**WELWYN HATFIELD BOROUGH COUNCIL
EXECUTIVE DIRECTOR - PLANNING, PUBLIC PROTECTION AND GOVERNANCE**

DELEGATED APPLICATION

Application No: 6/2021/1107/HOUSE
Location: 379 St Albans Road West Hatfield AL10 9RU
Proposal: Erection of a single storey rear extension, a two storey rear, front side extension, a roof extension and insertion of a rear box dormer.
Officer: Mr Raymond Lee

Recommendation: Refused

SCALE	1:100 @ A3
DATE	20210318
DRAWN	SDJ
DRAWING No	101

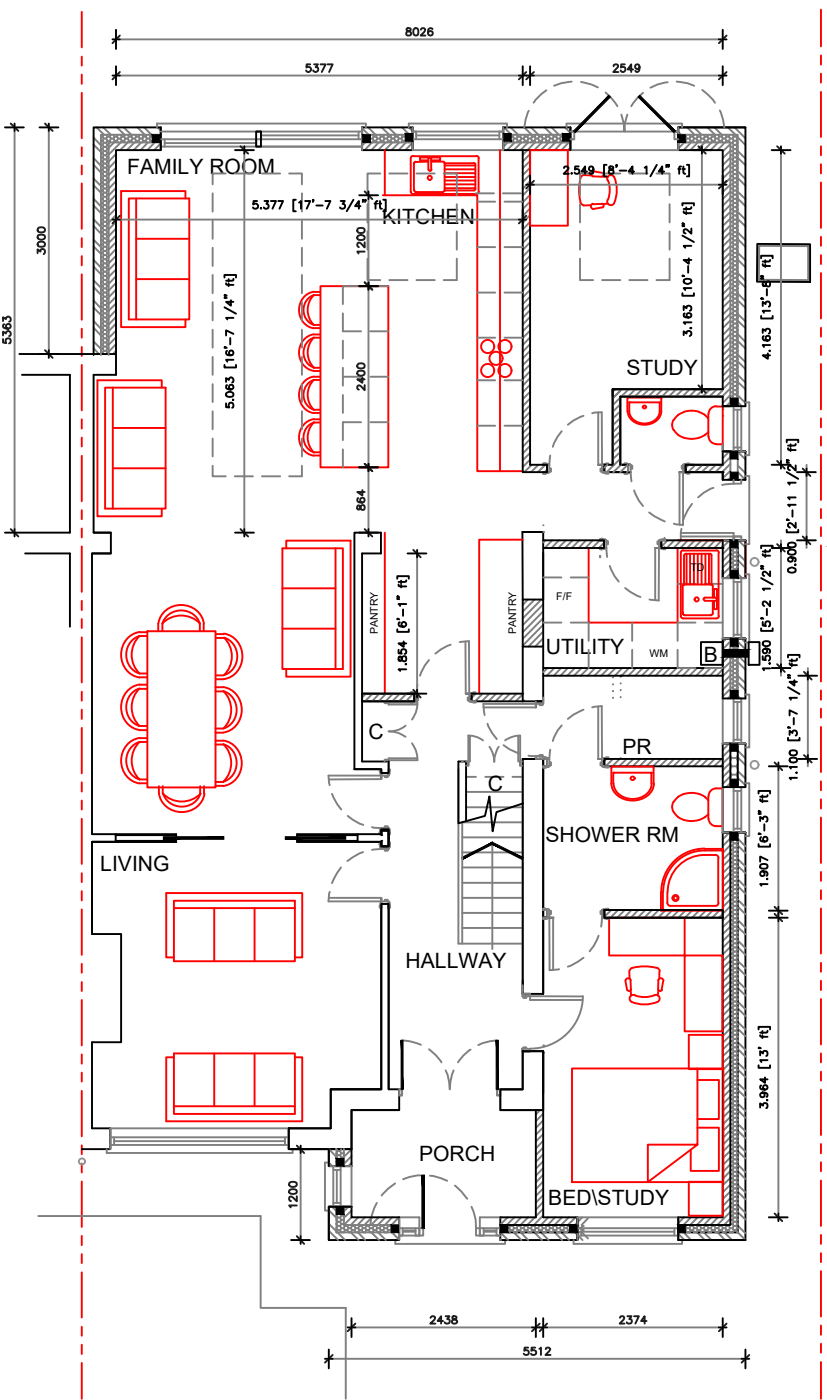
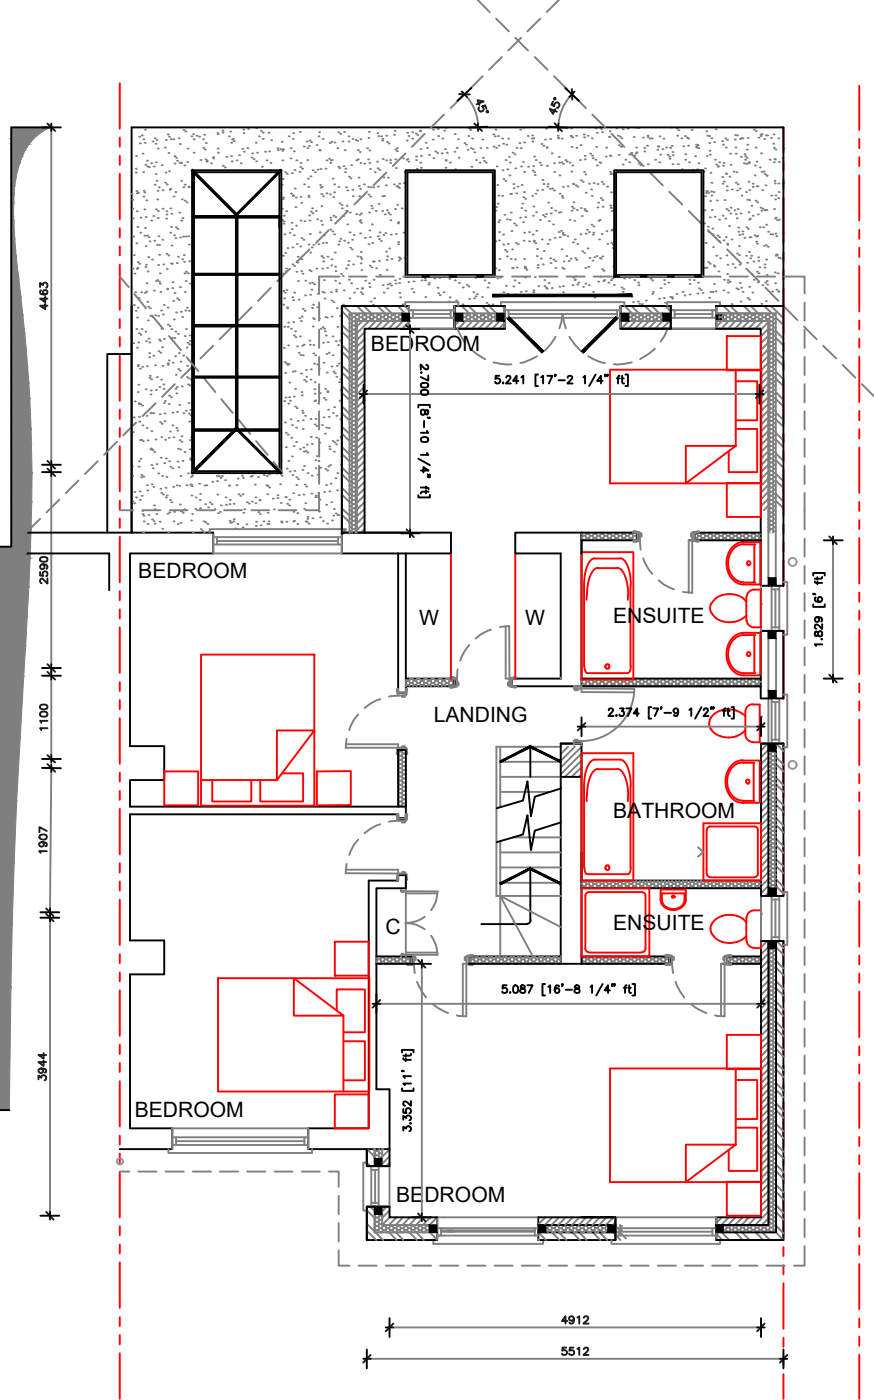
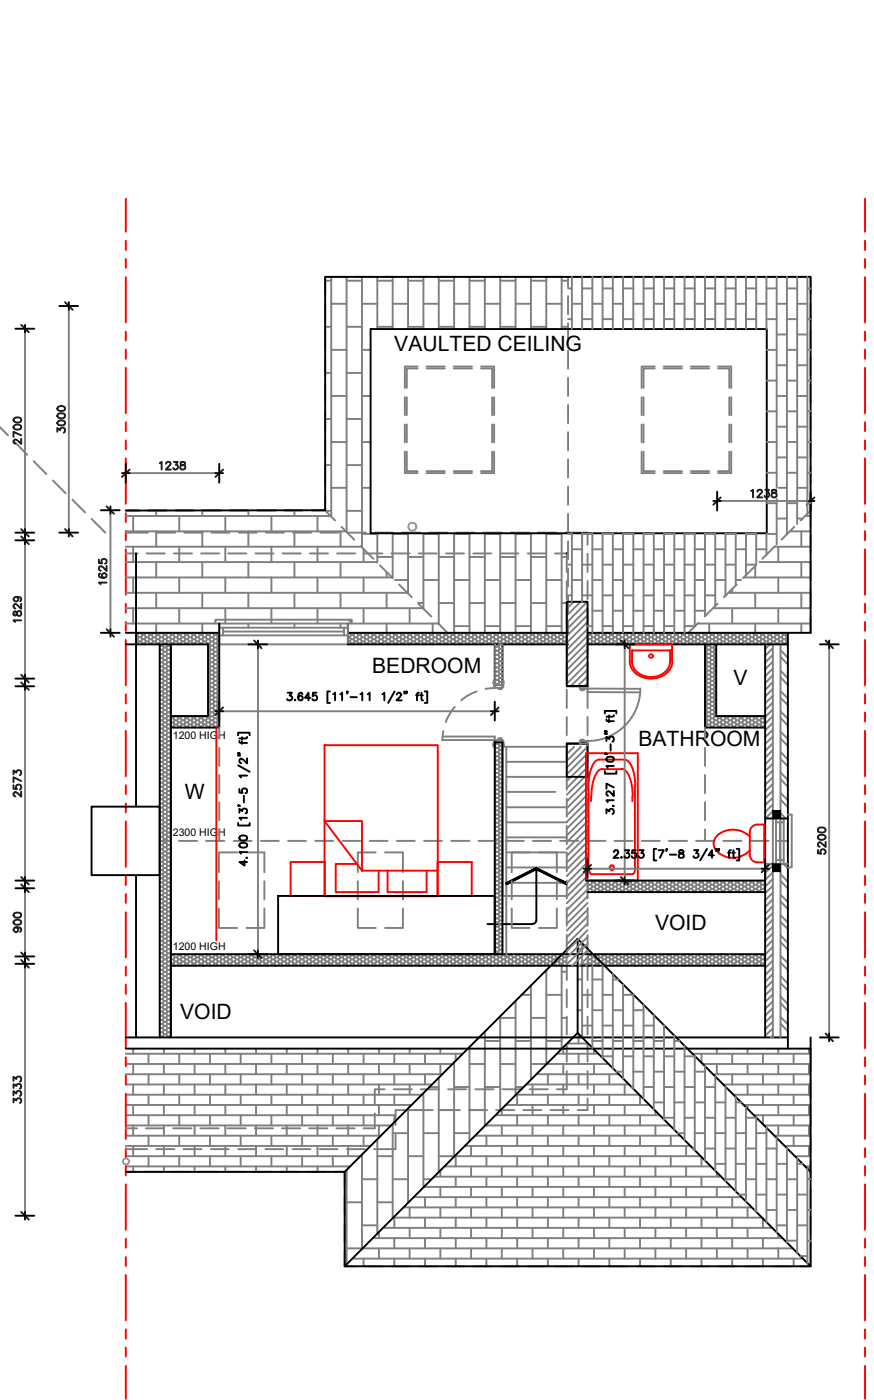
<p>Main Issues</p>	
<p>Design (form, size, scale, siting) and Character (appearance within the streetscene)</p>	<p>The National Planning Policy Framework (NPPF) chapter 12 emphasises the importance of good design as a key aspect of sustainable development. Paragraph 124 advises that the creation of high quality buildings and places is fundamental to what the planning and development process should achieve and that good design is a key aspect of sustainable development. Paragraph 127 the NPPF further advises that decisions should ensure developments will function well, be visually attractive, sympathetic to local character and establish a strong sense of place. Paragraph 130 is clear that “Permission should be refused for development of poor design that fails to take the opportunities available for improving the character and quality of an area and the way it functions...”.</p> <p>District Plan Policy GBSP2 of the Welwyn Hatfield District Plan 2005 notes that development within the specified settlements will be limited to that which is compatible with the maintenance and enhancement of their character. Policies D1 and D2 aim to ensure a high quality of design and to ensure that development respects and relates to the character and context of the locality, maintaining and where possible enhancing the character of the existing area. These policies are expanded upon in the Council’s Supplementary Design Guidance (SDG) which requires the impact of a development to be assessed giving regard to the bulk, scale and design of the proposal and how it harmonises with the existing building and area.</p> <p>In this case, substantial extensions are proposed to the original building. Although the footprint of the proposed development in comparison to the size of the plot is not considered to result in overdevelopment of the site, given the significant bulk that would be added to the front, side and rear of the building at</p>

<p>both ground and first floor level, it is not considered that these additions would be subordinate or subservient to the original dwelling.</p> <p>Whilst the principle of a well designed two storey side extension is not unacceptable in the area given the various examples that could be found along the street, in this instance the proposed two storey side extension would alter the current characteristic hipped roof to a much more prominent gable end that would visually unbalance the pair of semi's by creating a bulky roof on one side. This in addition to the other extensions proposed to the roof would significantly increase its massing and fundamentally change the appearance of the roof form. This part of the scheme would therefore fail to respect and relate to the host dwelling and the other pairs of semi-detached properties along the row.</p> <p>In terms of the two storey front extension, due to its excessive width and off centre location, it would result in a unduly prominent feature of the principle elevation of the property and would fail to appear as a subordinate addition. Furthermore, as there are no other examples of two storey front extensions in the immediate area, this would also result in a marked change in the character and appearance of this row of semi-detached properties.</p> <p>Although the proposed two storey element of the rear extension is appropriately stepped down from the main roof ridge, its width is greater than that of the two storey part of the original dwelling and therefore it is considered to be excessive in scale. With respect to the proposed box dormer to the rear, it is important to note that the Council's Supplementary Design Guidance states that dormer windows should be contained within the roof slope, be subservient to the roof, be set in by at least 1m flank wall/party wall of the property and be in proportion to the existing fenestration. In this case, since the proposed dormer is set in only approximately 0.6m from the common boundary with No. 377, this is considered contrary to the SDG. Although it is set down from the ridge and back from the eaves, given the extent of which it spans across the building, it would not be considered a subordinate or subservient addition to the existing roof slope.</p> <p>In terms of the detailed character of the development, the size, proportions and appearance of the doors and window being proposed is not, on balance, considered to harm the appearance of the dwelling or the character of the area. It is also proposed to utilise materials that would match the existing property which could be secured via condition in the event of an approval. This does not however overcome the harm in relation to the bulk and design of the proposals identified above.</p> <p>Cumulatively, the proposed extensions would overwhelm and dominate the original building, obscuring its original design and proportions and would fail to respect the character of the area. The proposed development is therefore excessive and of a poor standard of design that is contrary to the NPPF and Policies GBPS2, D1 and D2 of the District Plan which attach great importance to the design of the built environment and the SDG which seeks a design led approach to development.</p>

<p>neighbours would be those located to either side of the application site (No. 377 and No. 381 St Albans Road West).</p> <p>The neighbours at No. 377 have objected to the scheme on grounds of overshadowing to their living room from the single storey extension. Whilst the proposal would extend approximately 5 metres along the shared boundary with this neighbour, there is currently a circa 2m extension at No. 377 and therefore the proposal would only extend approximately 3 metres beyond their rear building line. Given that a relatively low flat roof form is proposed and the fact that No. 377's living room is served by a set of patio doors, it is not considered that this part of the scheme would result in significant loss of light or appear unduly dominating. The two storey part of the rear extension would be set in approximately 2.5m from the boundary and therefore it would not result in detrimental loss of light or outlook. In terms of privacy, whilst there are a series of side facing windows proposed which could afford views onto the neighbouring property at No. 377, since these openings serve non-habitable rooms, it would be considered reasonable and appropriate to obscure glaze these windows by condition in the event of an approval to overcome the privacy issue.</p> <p>As for the neighbour on the other side at No. 381, given the location of the development in relation to their primary windows and main amenity areas, it is judged that the proposal would not have an unacceptable impact on the levels of light or outlook. In terms of privacy, there are no side window proposed that would face onto these neighbours and the additional rear facing openings would not afford greater views than the current situation that would impinge on their privacy.</p> <p>Overall, subject to conditions in the event of an approval, the proposal would broadly comply with Policies D1 of the District Plan; the Supplementary Design Guidance and NPPF in relation to maintaining the living conditions of any neighbours.</p>

<p>Any other considerations</p>	<p>None.</p>
<p>Conclusion</p>	
<p>Having regard to the above, the proposed extensions, by virtue of their scale, form and design fails to reflect the proportions of, or be subordinate in scale to, the original dwelling. The proposal would therefore result in visually over dominant additions to the dwelling which fails to reflect the design and character of the property and which would be detrimental to the character of the streetscene. Accordingly the proposal represents a poor standard of design that would be contrary to policies D1</p>

1. The proposed extensions, by virtue of their scale, form and design fails to reflect the proportions of, or be subordinate in scale to, the original dwelling. The proposal would therefore result in visually over dominant additions to the dwelling which fails to reflect the design and character of the property and which would be detrimental to the character of the streetscene. Accordingly the proposal represents a poor standard of design that would be contrary to policies D1 and D2 of the Welwyn Hatfield District Plan 2005, the Supplementary Design Guidance 2005 and the National Planning Policy Framework .
